RE: MITCHELL ELEMENTARY SCHOOL CAFETERIA ADDITION G-21/D033

RE: Mitchell Elementary - School Cafeteria Addition
Grade & Drain Plan for SO-19 & Building Permit

G21-D033

**Re: Mitchell Elementary School Cafeteria Addition Grading and Drainage Plan
Engineer's Stamp date 06-27-2012 (G-21/D033)**

TRENCH DRAIN LAYOUT

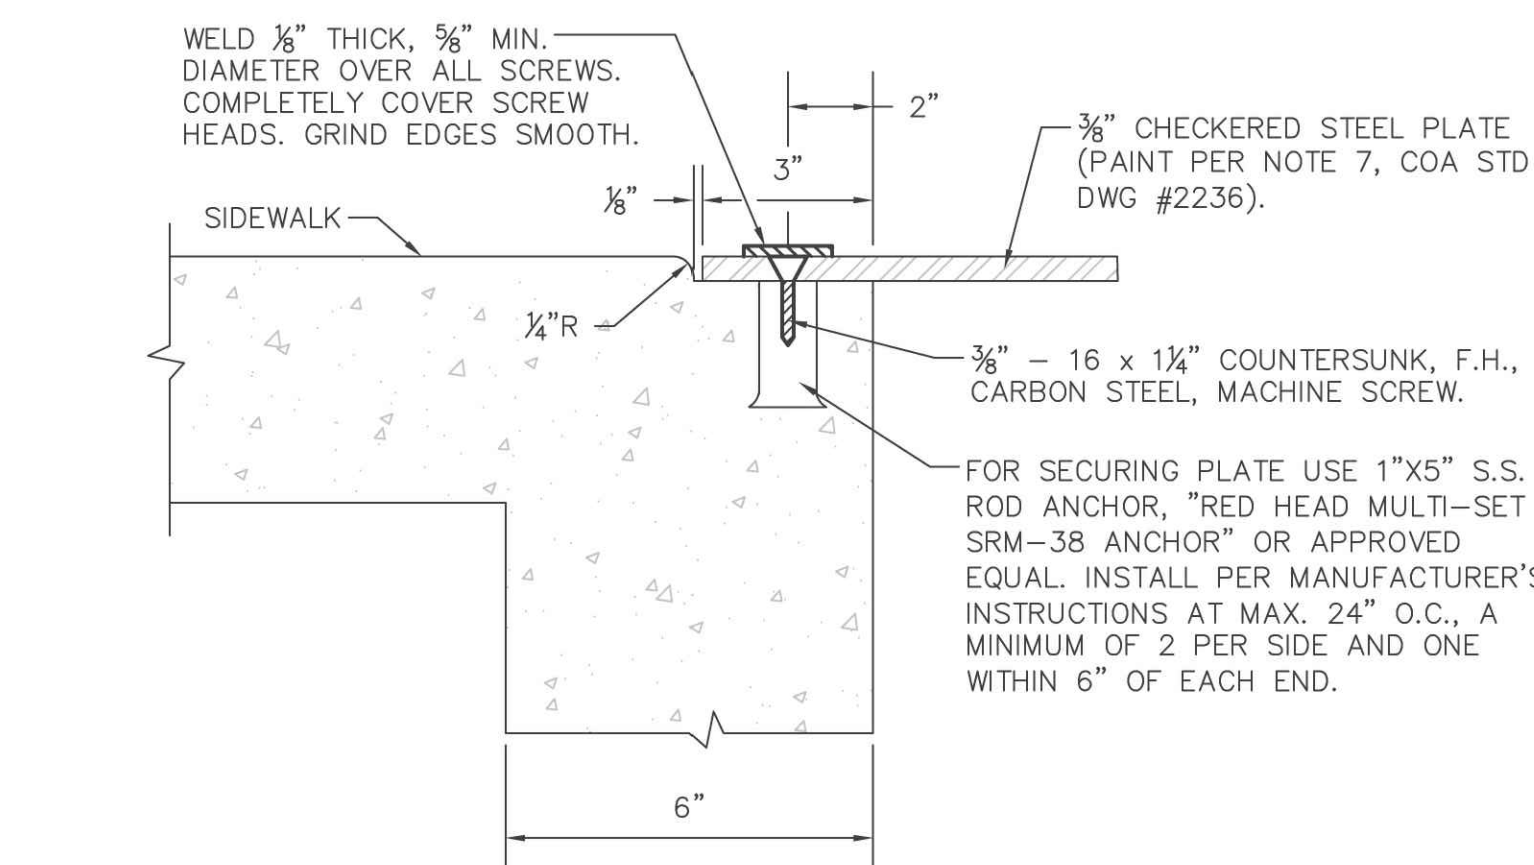
8. Note that the Trench Drain design calls for a K900 Inline Inlet, but I found that the K900 Inlets do not have cut-outs for the 8" size outfall proposed.

1. Sidewalk culvert has been extended 2' east of the back of walk.
2. Culvert capacity calculations have been provided.
3. Water harvesting basin has been enlarged and deepened to provide additional volume.
4. Erosion protection has been clarified.
5. Storm drain pipe cover has been addressed.
6. Keyed notes labels have been moved to their proper locations.
7. The improvements on the east side of the building will be concrete (now noted).
8. Trench drain design has been updated.

COVERED SIDEWALK CULVERT - WELDED COVER

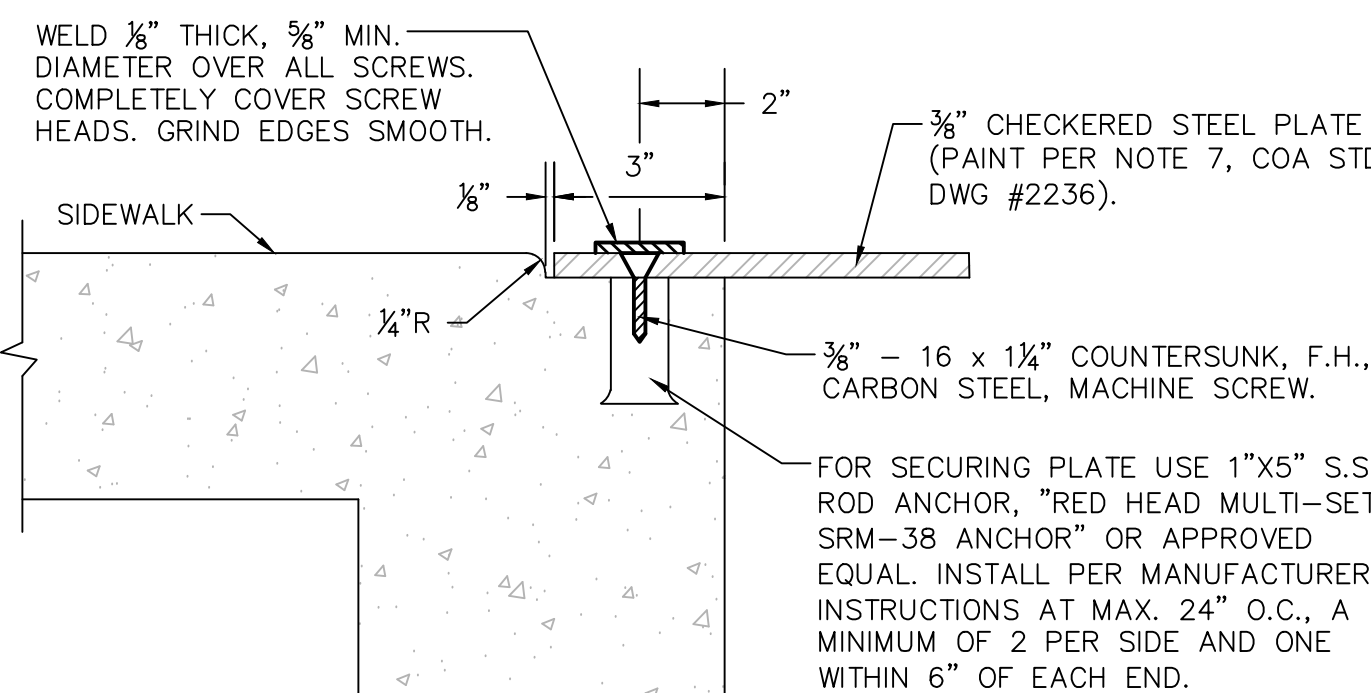
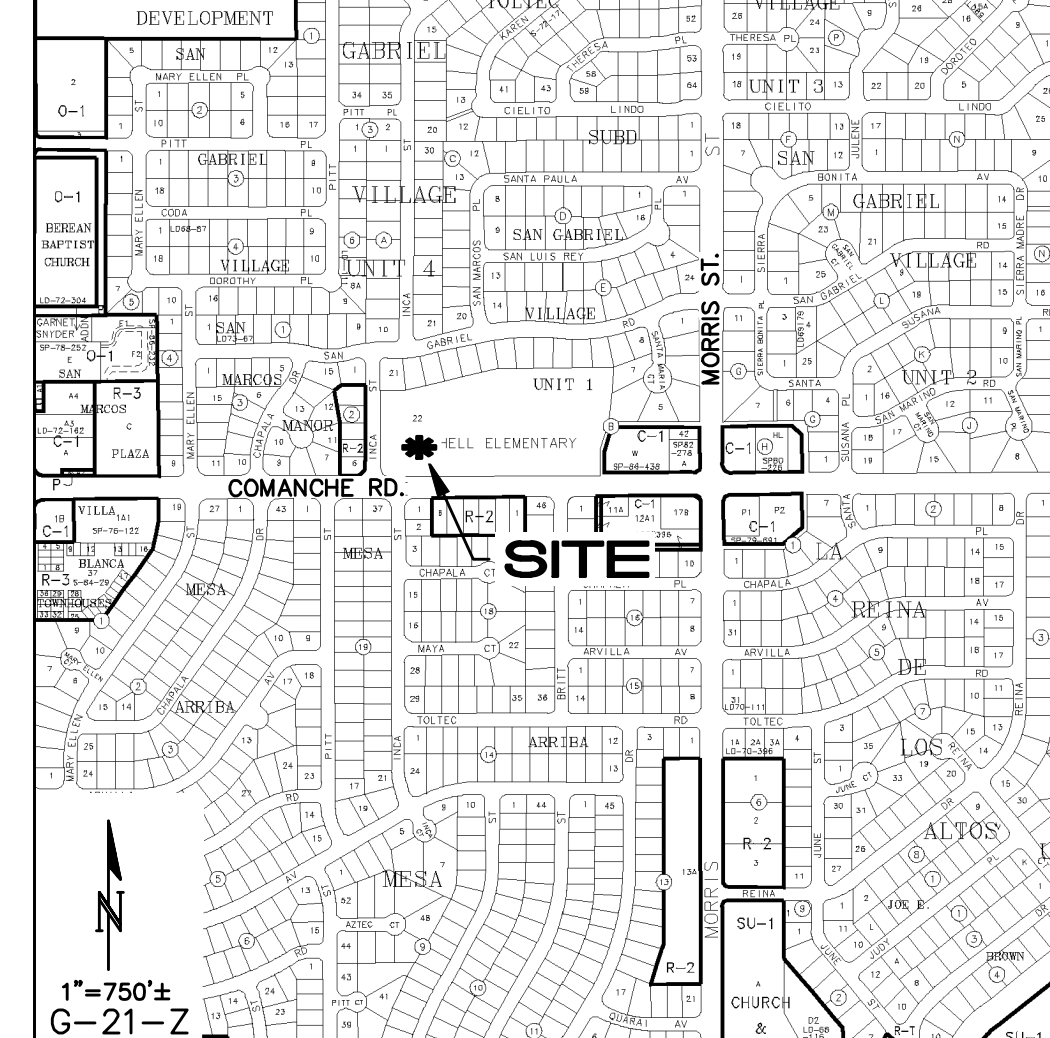
1. The sidewalk culvert should extend two feet east from back-of-sidewalk on Inca.
2. Provide culvert capacity calculations for the proposed sidewalk culvert.
